28 April, 2020

Harbourside Shopping Centre Redevelopment SSD-7874

2 Shadow Projection JUN 1400
2pm

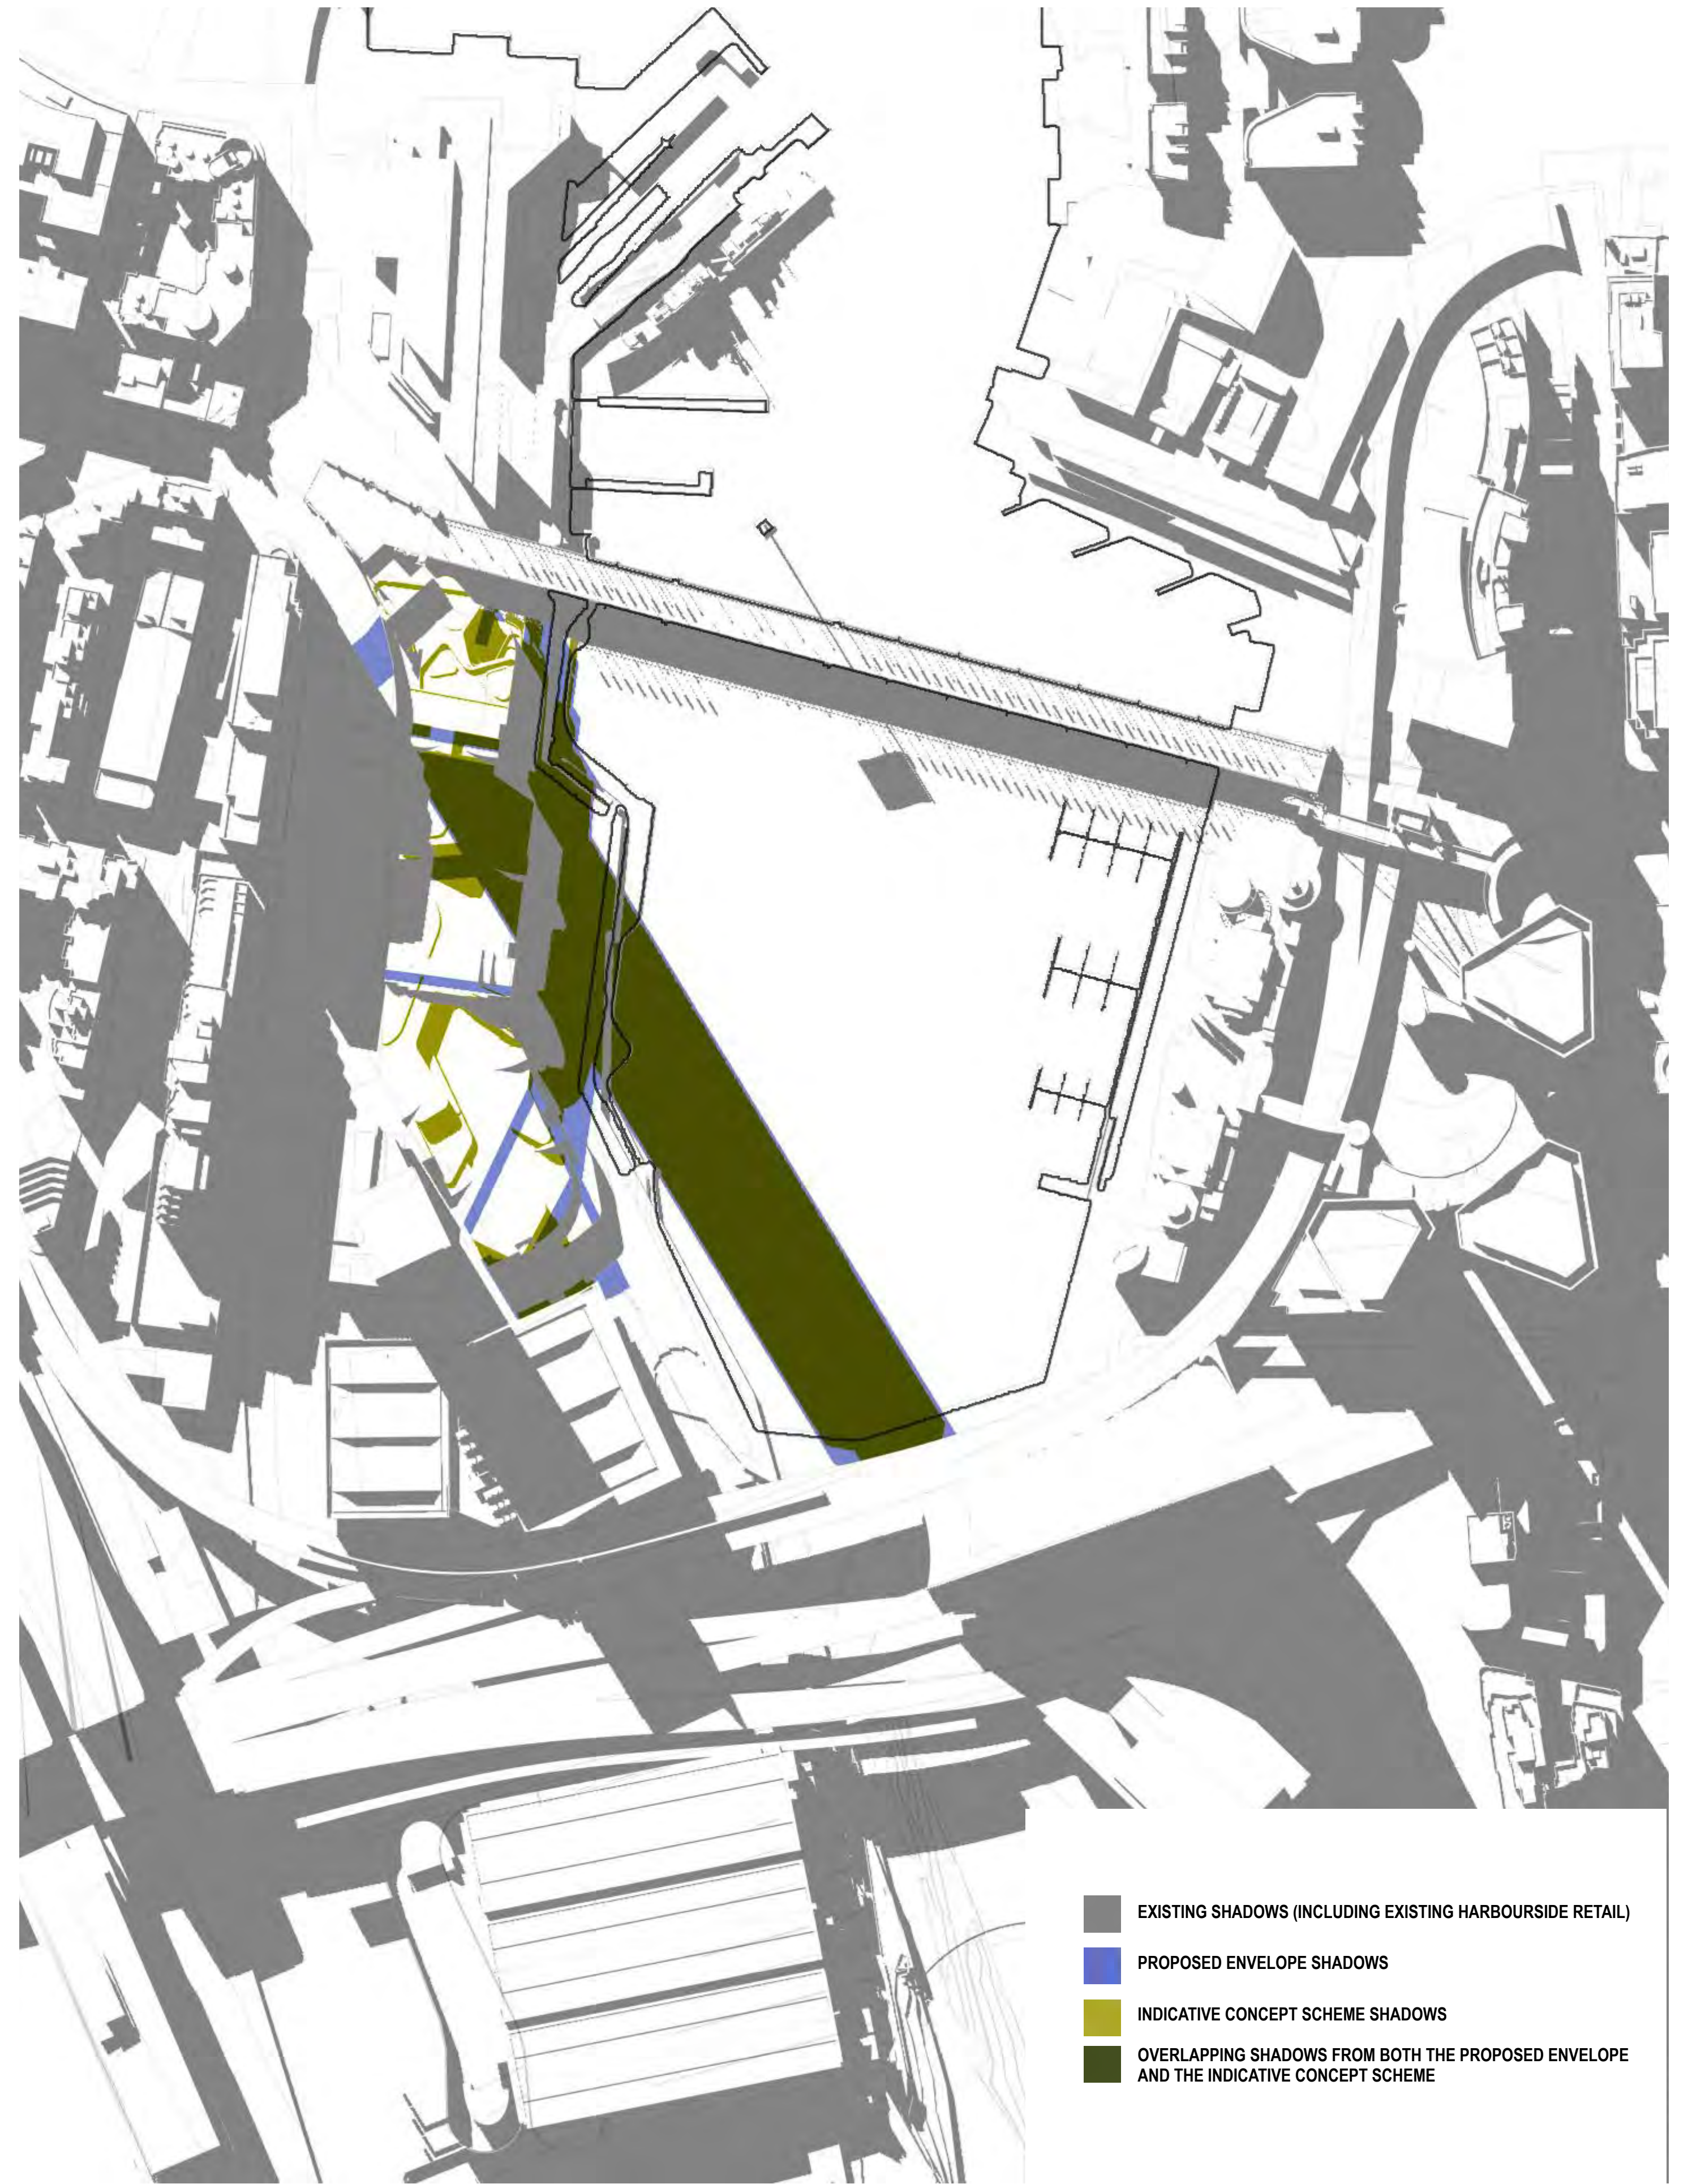
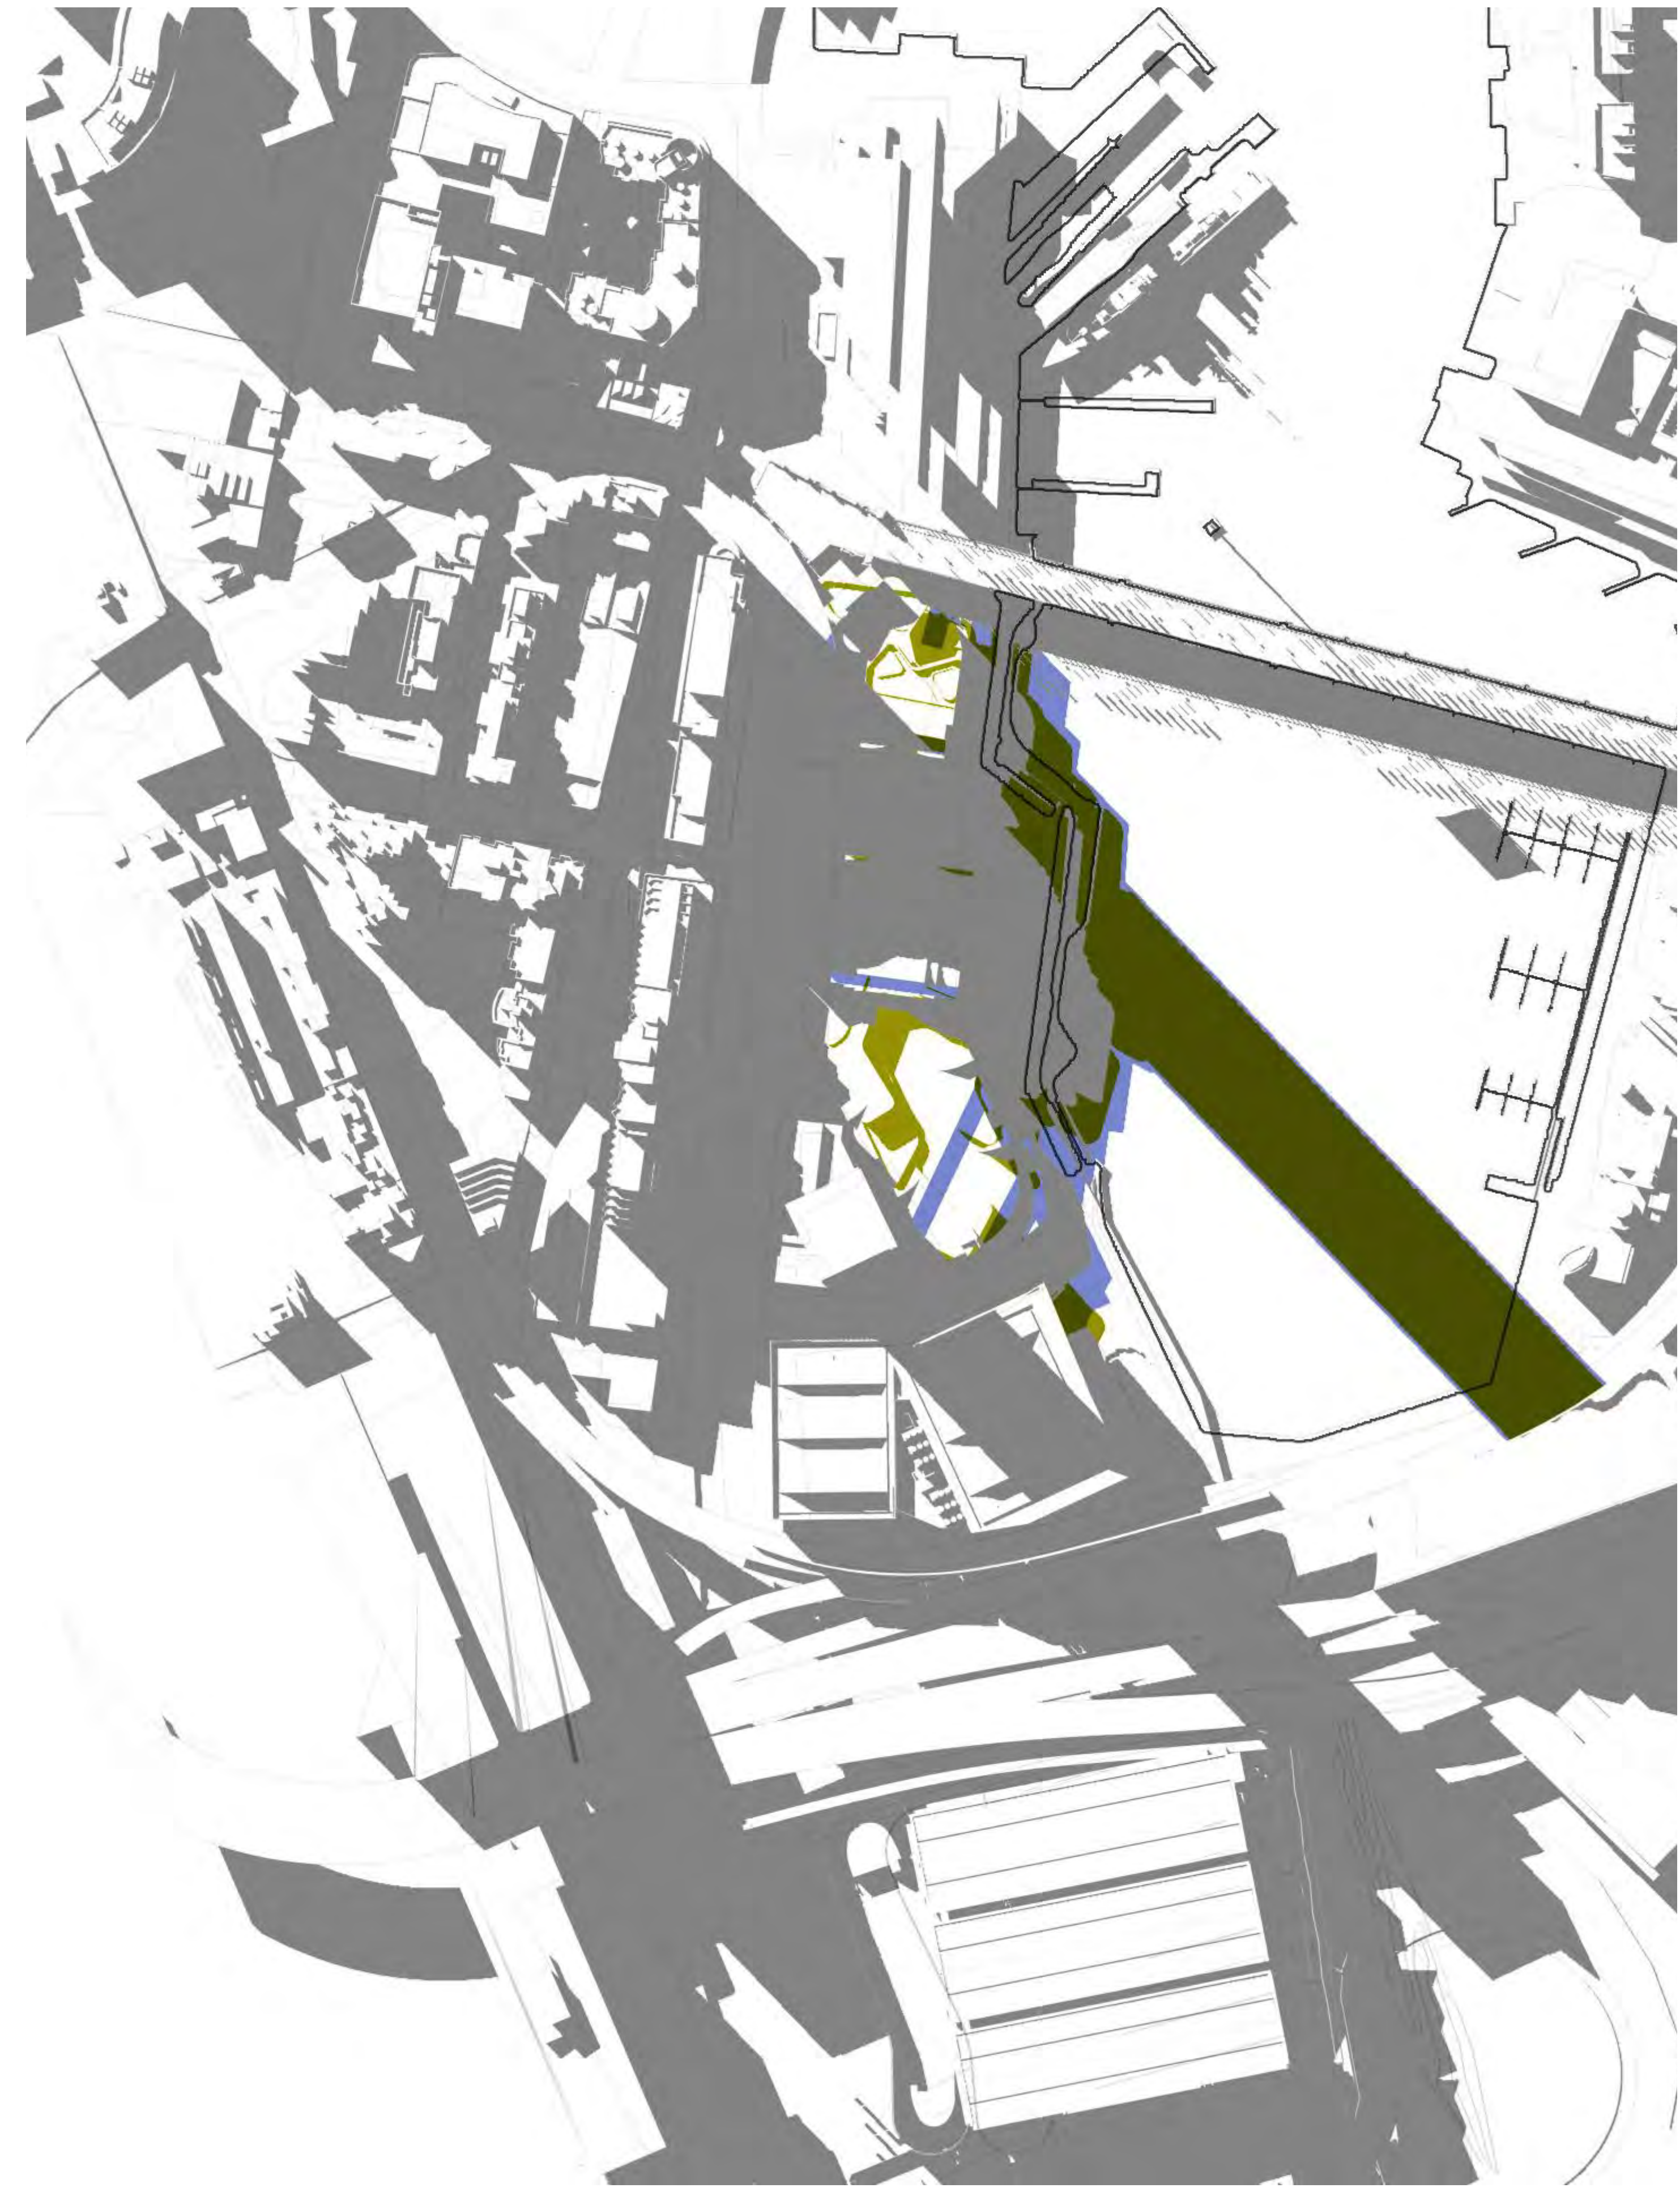
The proposed new podium appears to reduce the width of the existing promenade and increase overshadowing, compounding the impacts of the overshadowing from the new tower proposal particularly in the colder months of the year.
